**High Street, Great Houghton  
Proposed Residential Development  
Response Report to Combined Stage 1 and 2 Road  
Safety Audit**

February 2026 (Rev 1)

High Street, Great Houghton - Response Report to Combined Stage 1 and 2 Road Safety Audit Project No: 21069					
<b>File reference</b>	O:\High Street, Great Houghton\TEXT\REPORTS\260227 High Street Great Houghton - Designers Response Report (Rev 1).docx				
<b>Issue/revision</b>	<b>Initial Issue</b>	<b>Revision 1</b>	<b>Revision 2</b>	<b>Revision 3</b>	<b>Revision 4</b>
<b>Remarks</b>	Final	RSA Actions			
<b>Date</b>	3 <sup>rd</sup> February 2026	26 <sup>th</sup> February 2026			
<b>Prepared by</b>	R Peach	R Peach			
<b>Signature</b>					
<b>Checked by</b>	S Chapman	S Chapman			
<b>Signature</b>					
<b>Authorised by</b>	M Whittaker	M Whittaker			
<b>Signature</b>

VISIBILITY SPLAY -
S78/S38 JUNCTION &
SUBSTATION
SCALE - 1:200

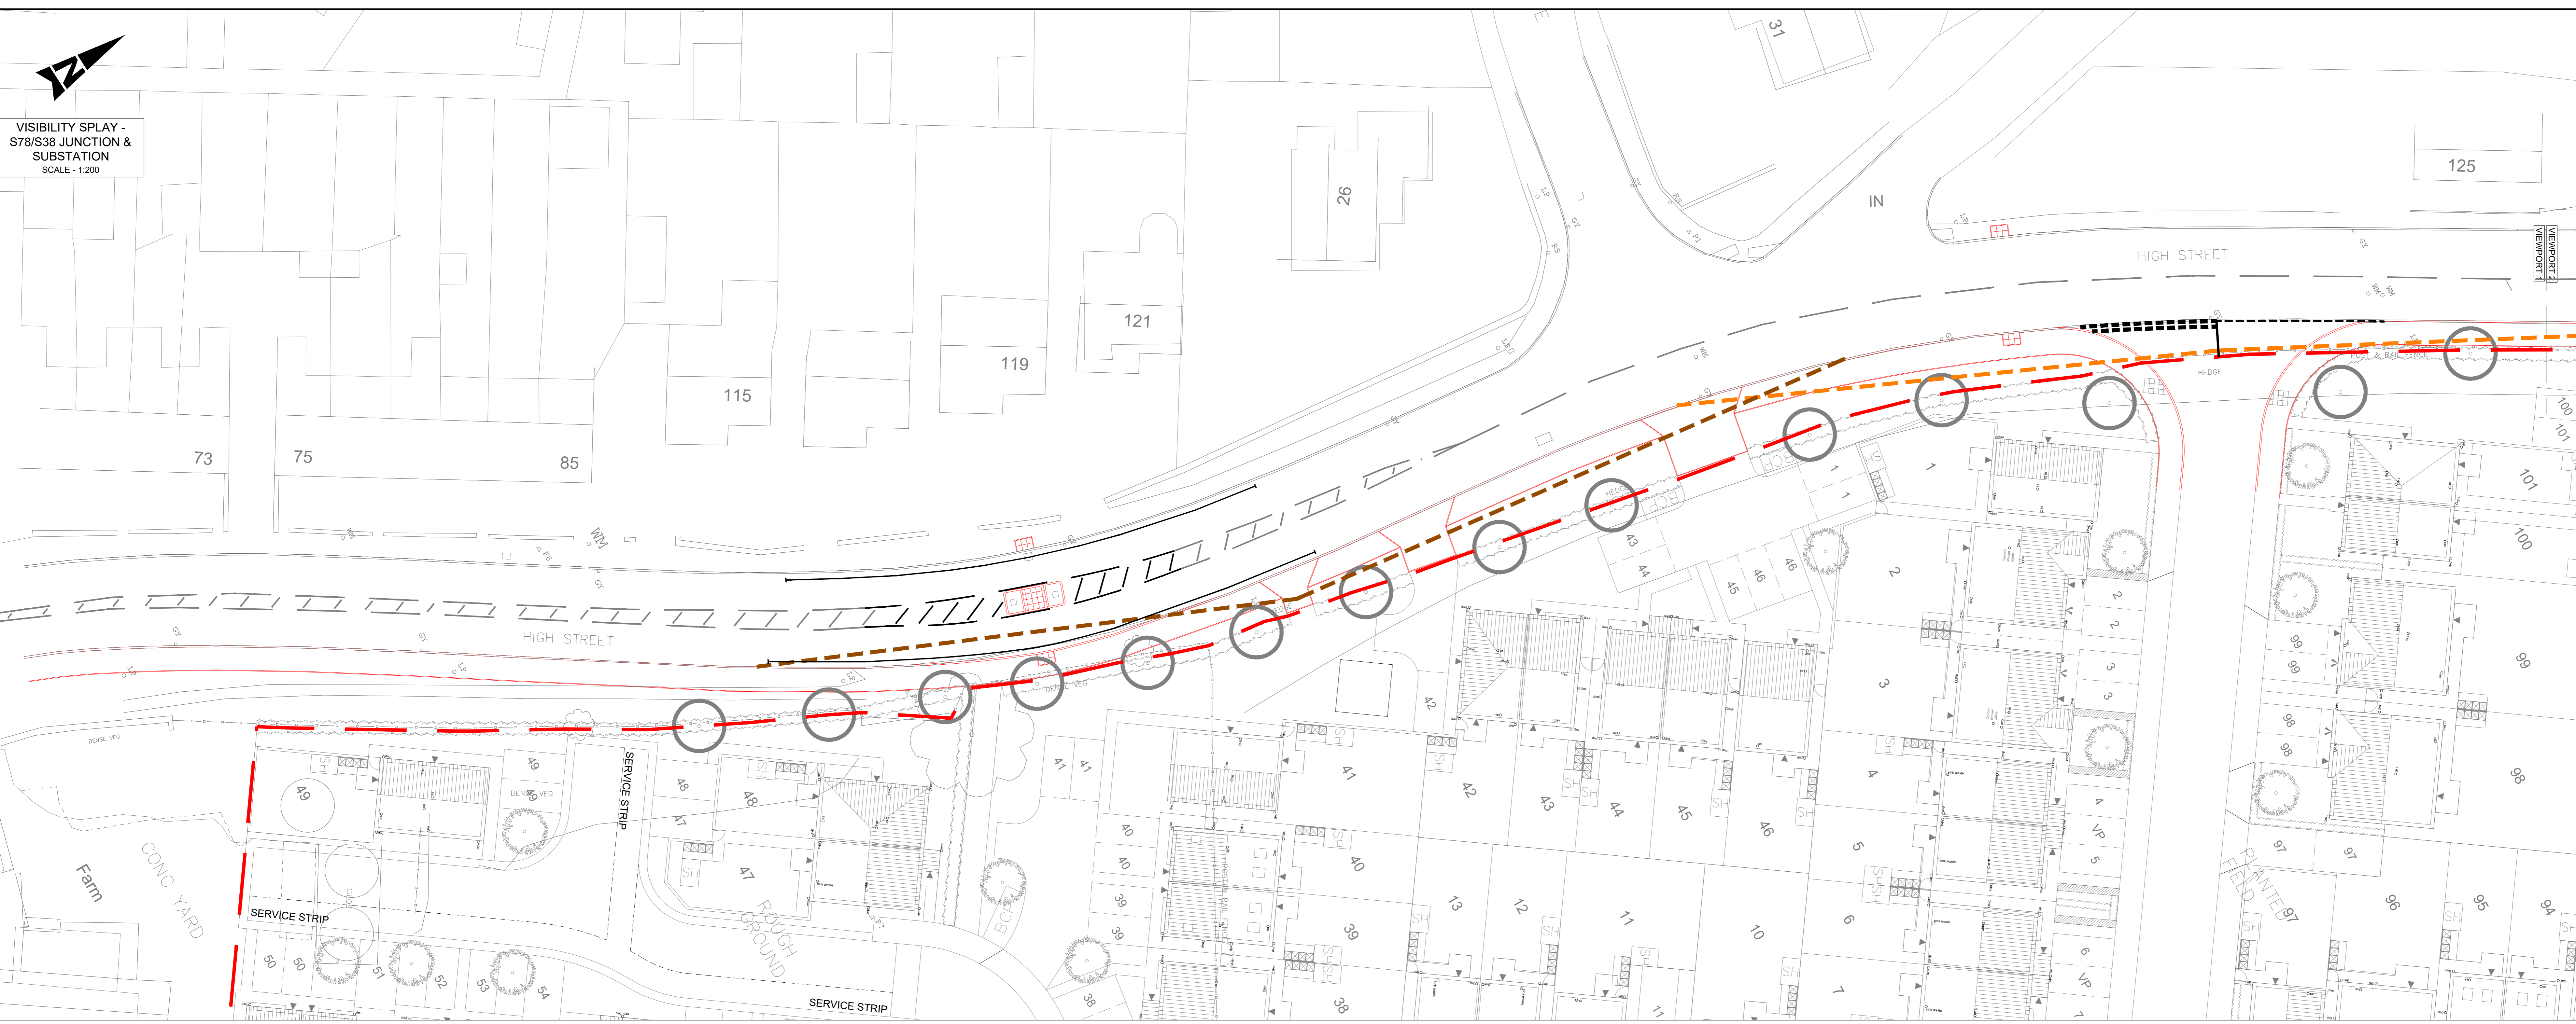
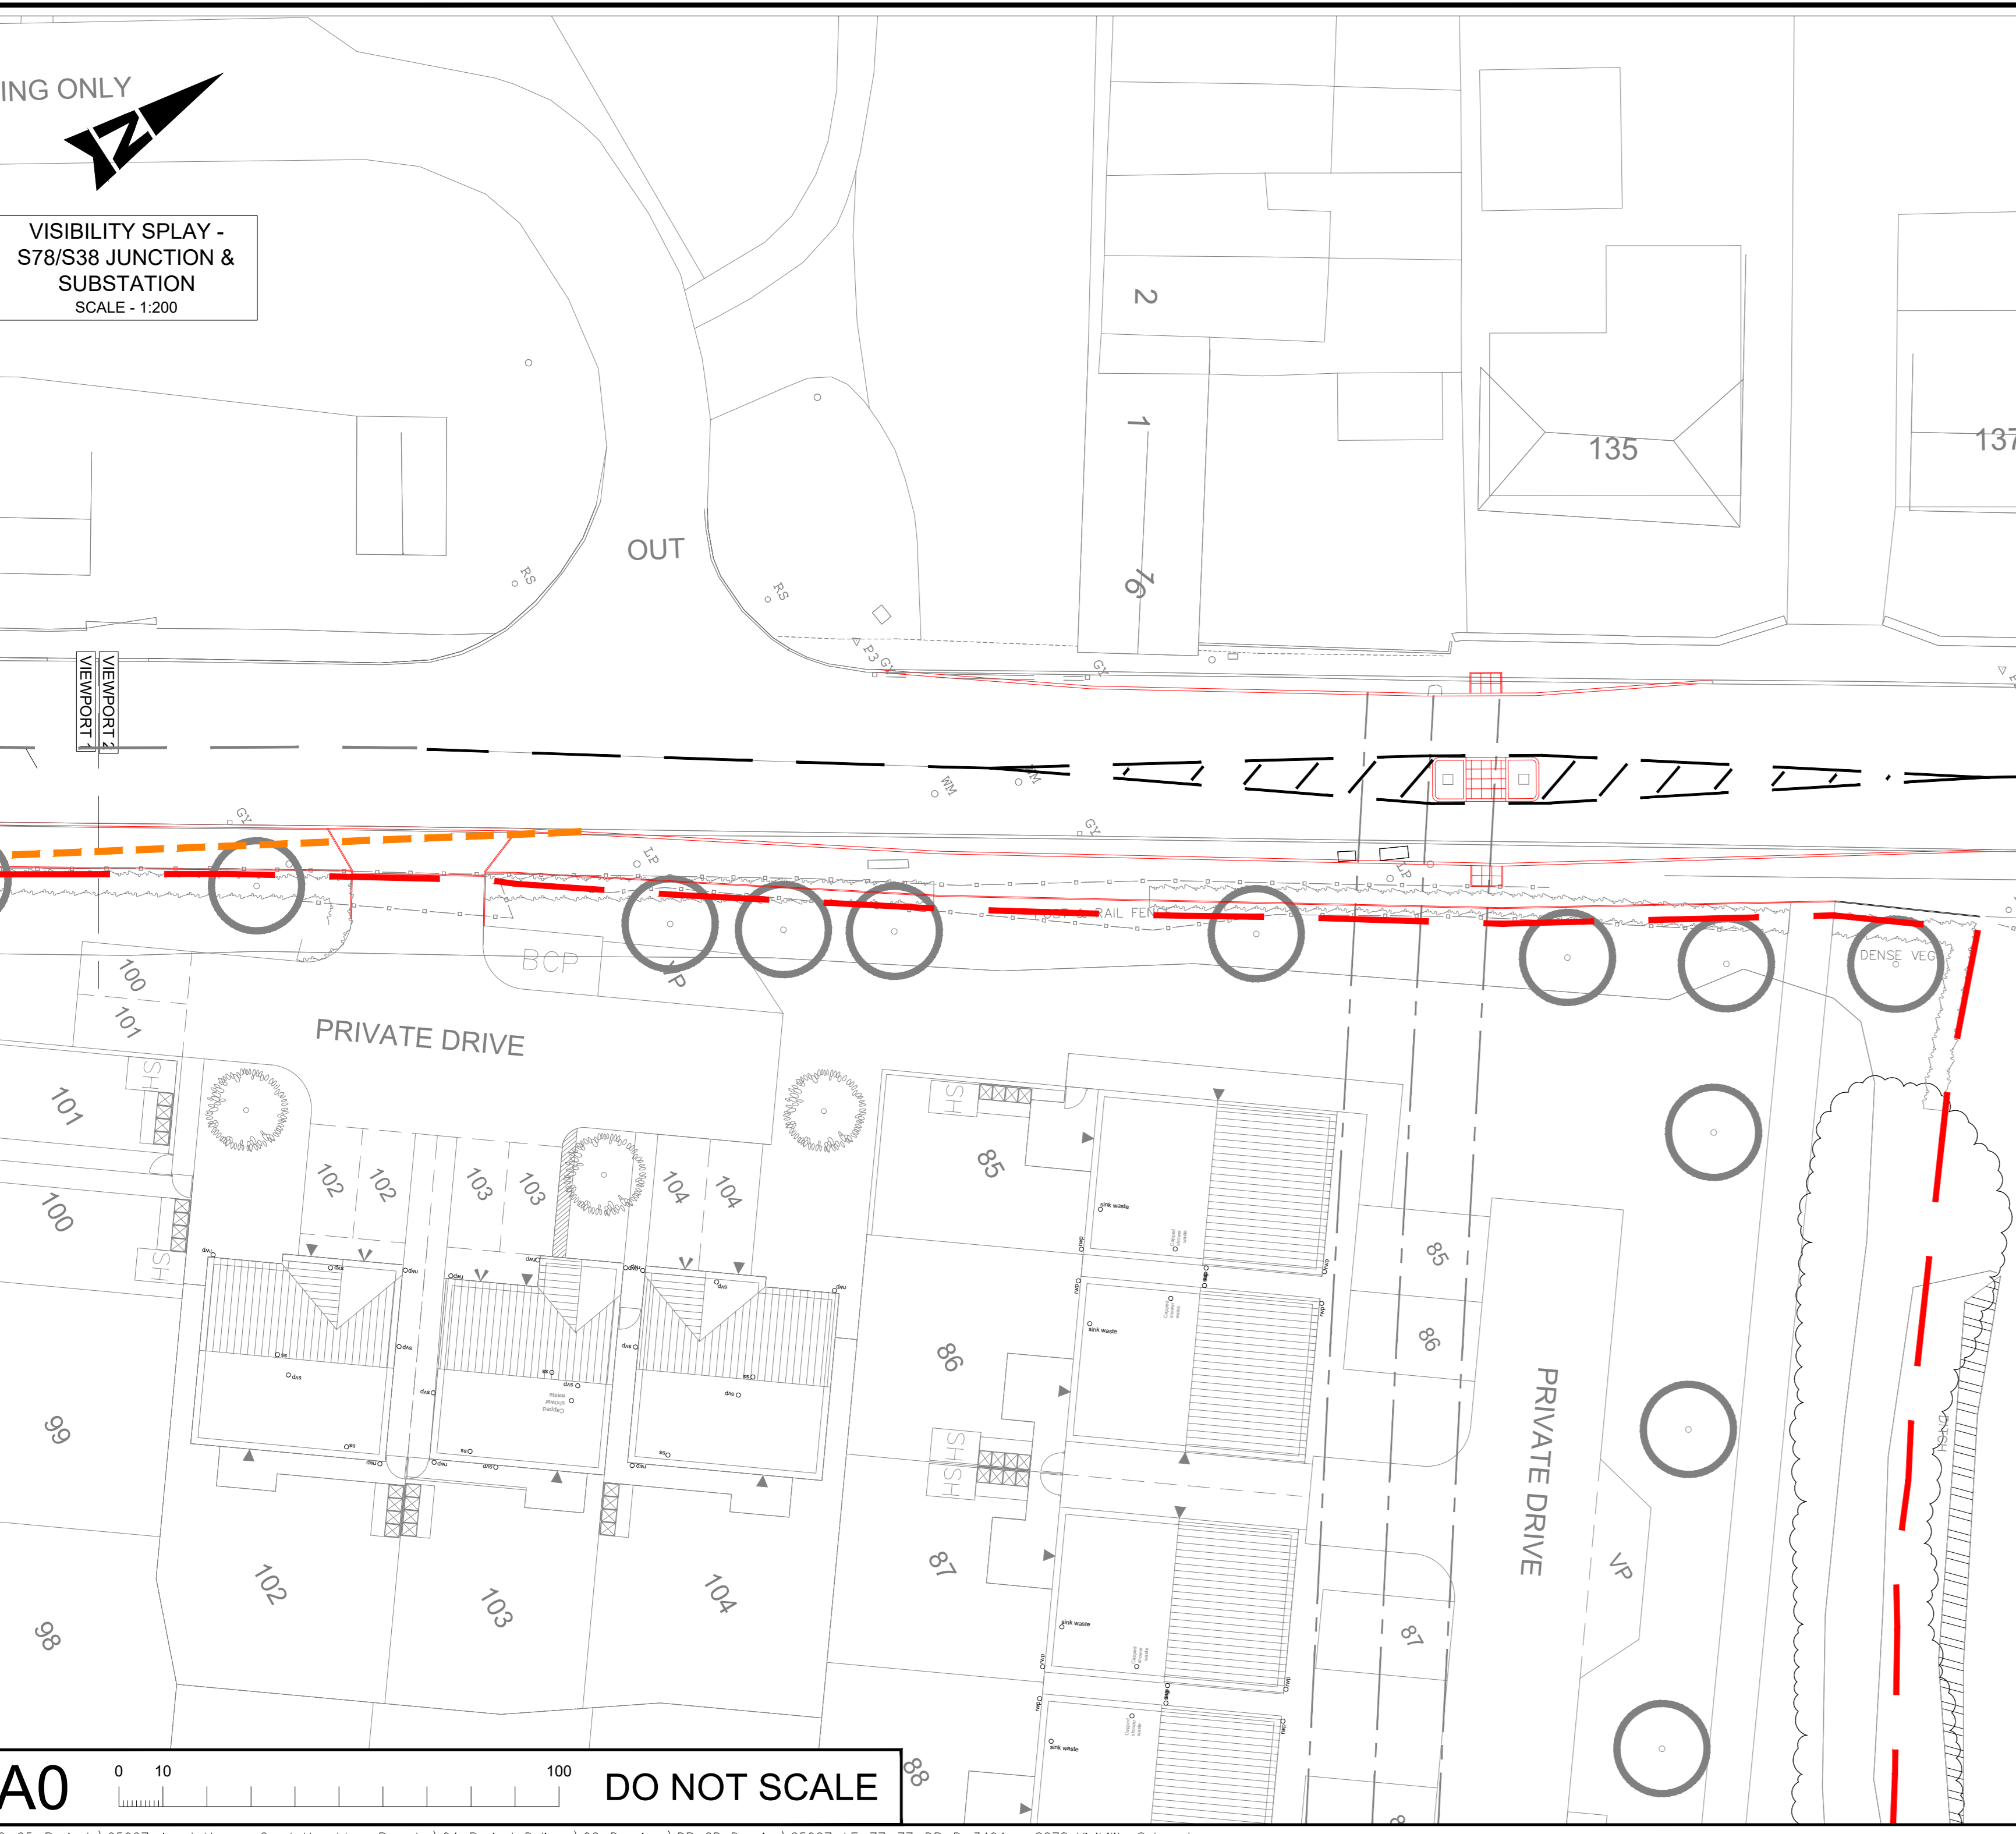
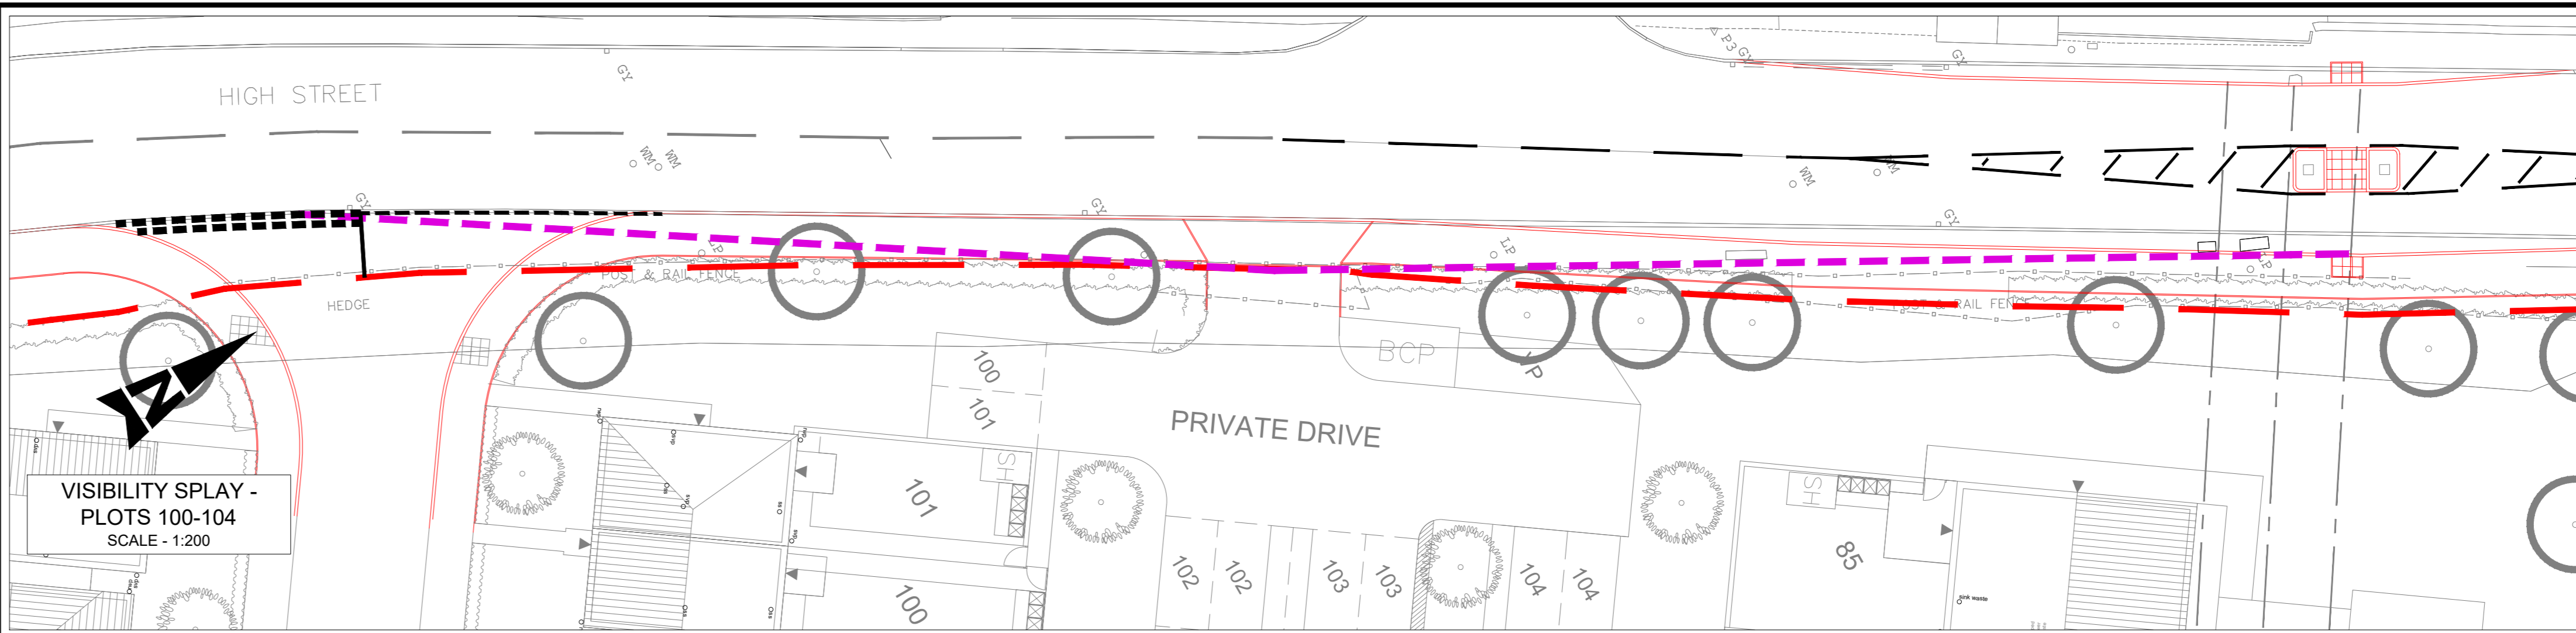
<p><b>3.2.2</b> <b>Location:</b> Development access junction and other proposed vehicle accesses on High Street <b>Summary:</b> Potential for vehicle-to-vehicle collision. <b>Detail:</b> Some of the intended visibility splays include areas of highway verge and are adjacent to property boundaries. If landscaping, hedges, etc. are within the visibility splays, collisions with involving turning traffic are possible, if the correct visibility distances are not achieved in practise.</p>	It is recommended that the visibility splays are kept clear of obstructions e.g. landscaping, property boundary fencing, advertising boards, etc.	<b>Accepted</b> – The proposed visibility splays will be kept clear of obstructions. Visibility splays from all junctions are provided within the adopted highway.	Comments accepted.	No further action required.			
<p><b>3.3.1</b> <b>Location:</b> High Street northbound lane, at the proposed refuge island outside No. 119 <b>Summary:</b> Potential trip hazard. <b>Detail:</b> The inspection cover outside No. 119 High Street is a possible trip hazard for pedestrians using the new refuge island.</p>	It is recommended that either the crossing or the manhole are relocated. If this is not practical, it is recommended that a non-slipcover is installed and that the carriageway is suitably reinstated.	<b>Accepted</b> – The manhole will have a non-slip cover installed and the surrounding carriageway is to be appropriately reinstated - as noted on the Optima Highways Drawing No. <b>21069-GA-03-B</b> in <b>Appendix B</b> .	Comments accepted.	No further action required. Design drawings to reflect the information shown on <b>21069-GA-03-B</b> .
